Norfolk Boreas Offshore Wind Farm Development Consent Order (DCO) (the Project)
Case reference no: EN010087
The Applicant: Norfolk Boreas Limited

Response to section 51 advice

We write further to the Planning Inspectorate's section 51 advice dated 24 July 2019 (the **s51 advice**) and respond to the matters raised in the s51 advice in turn.

Special Category Land Plans

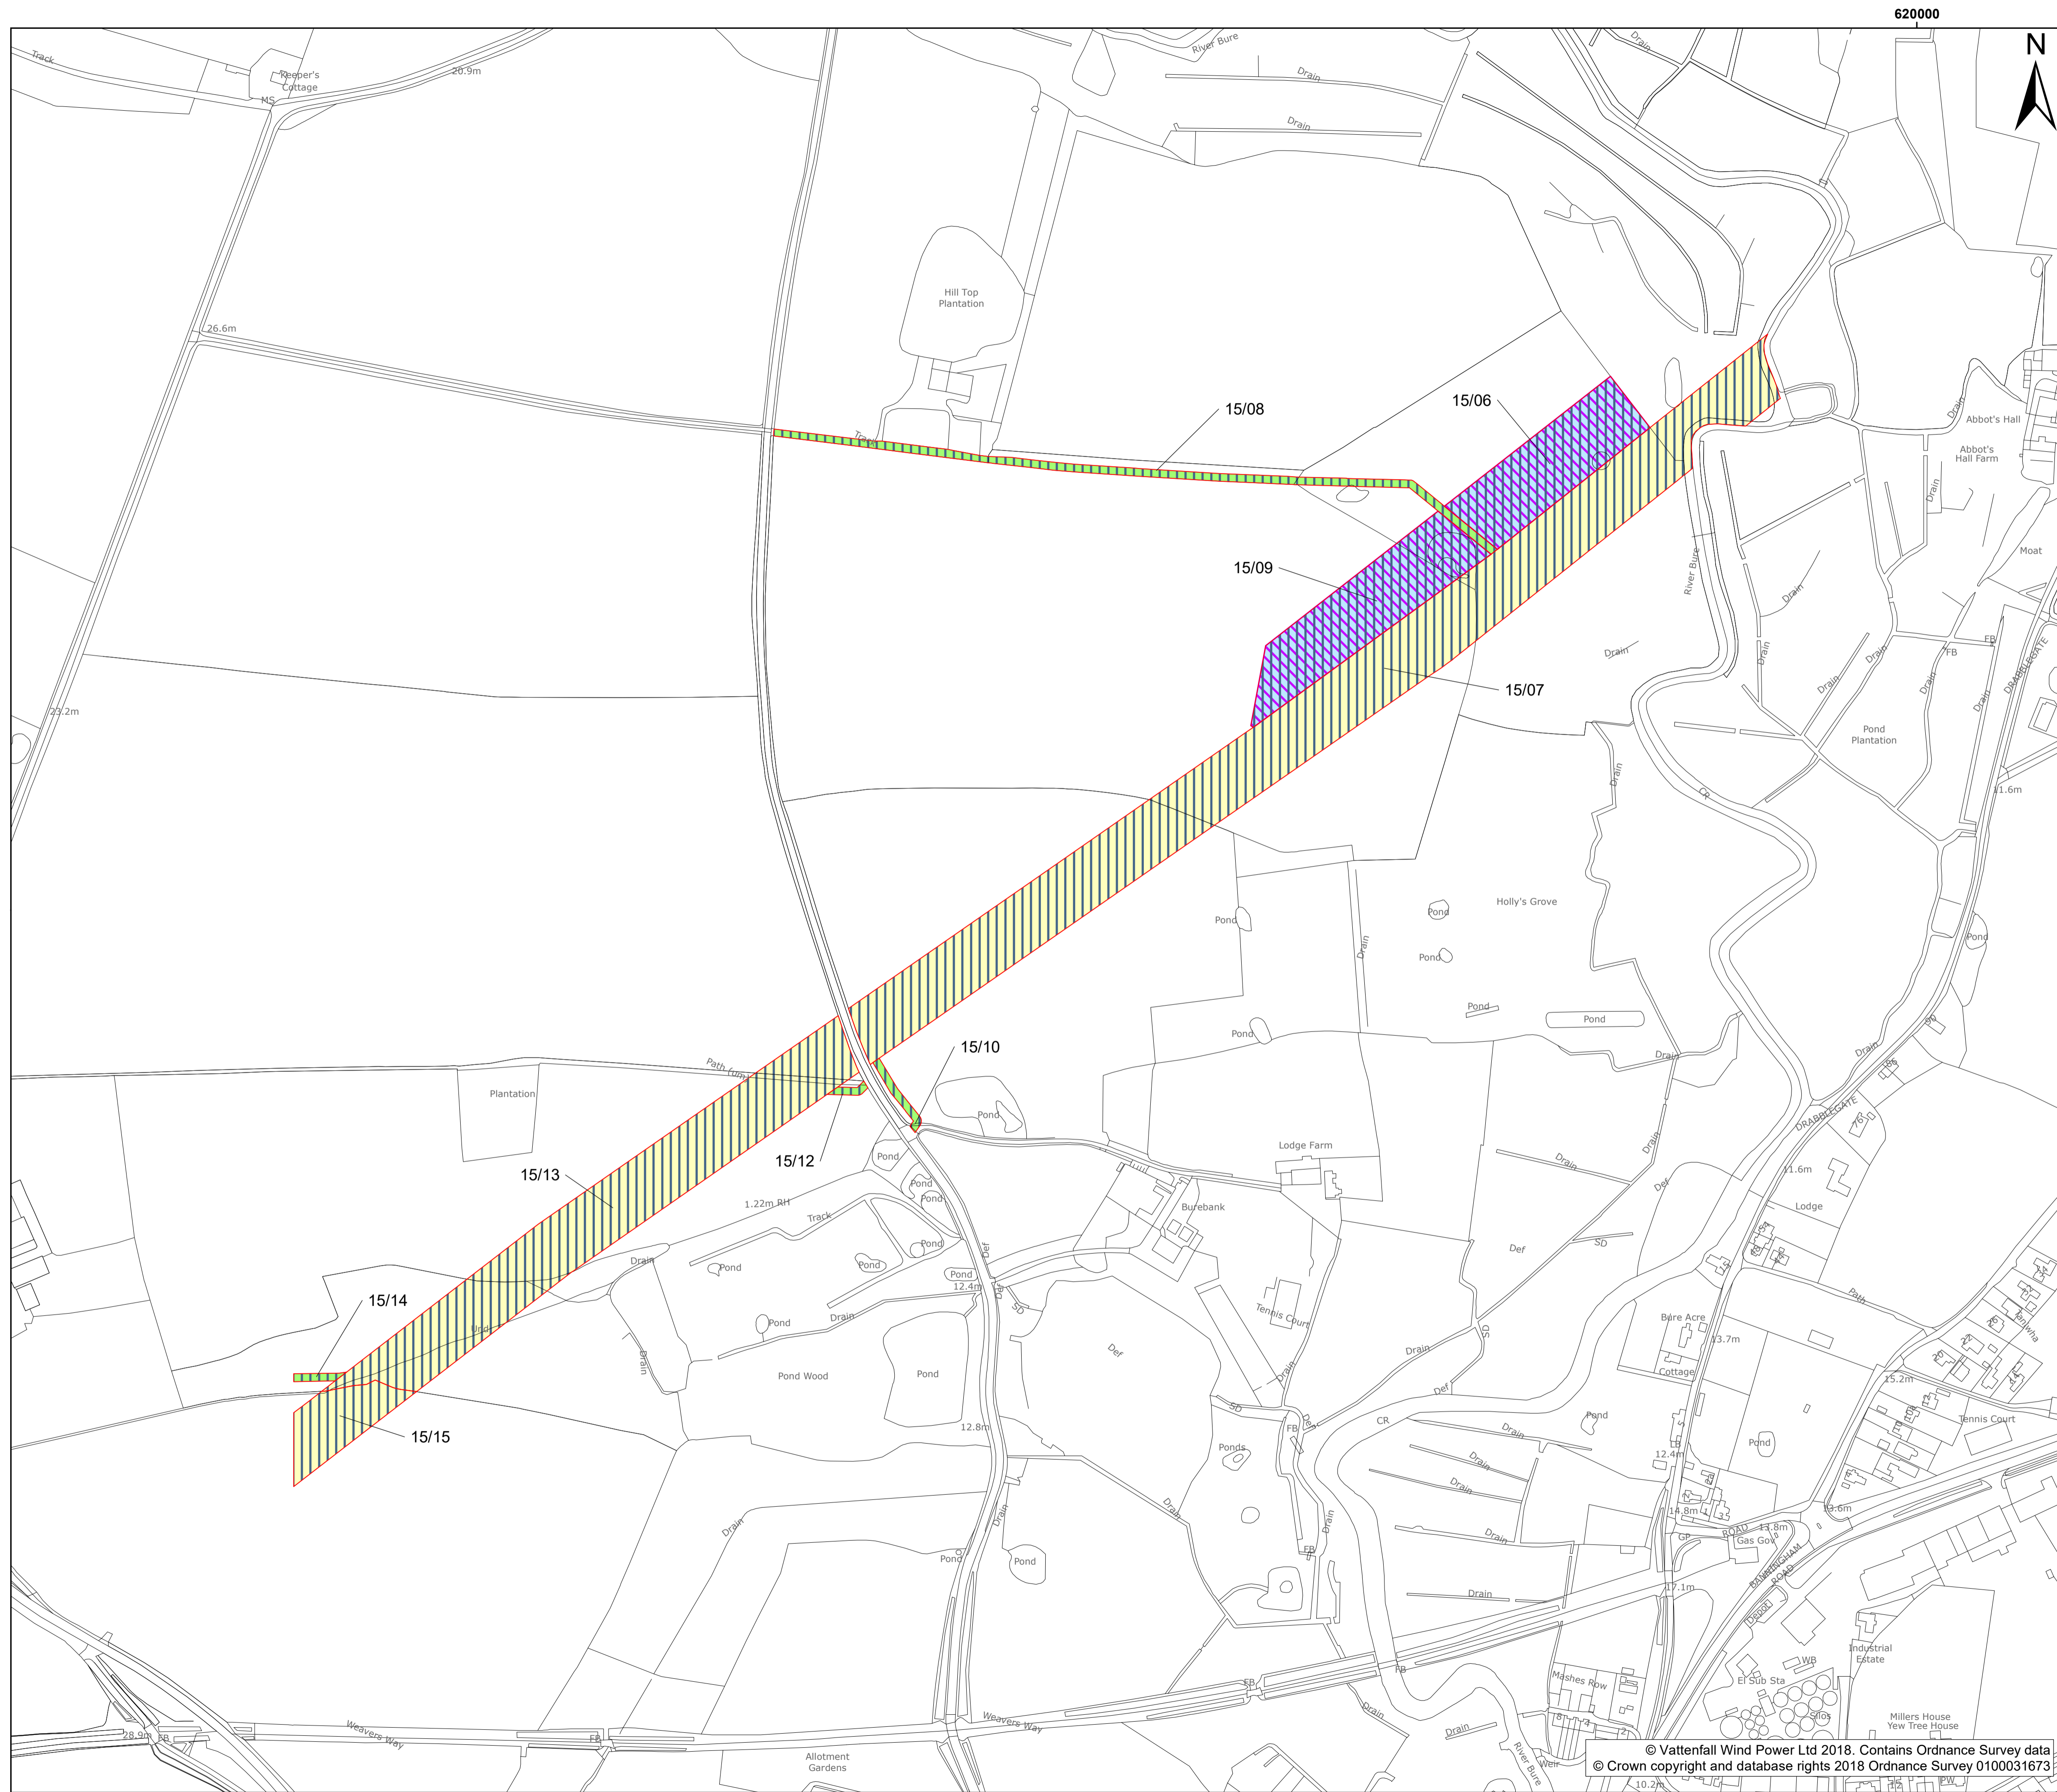
- 4.1 The Applicant has updated the Special Category Land Plan (document reference: 2.3) to include a key plan. The Applicant encloses a revised version of the plan with this letter.
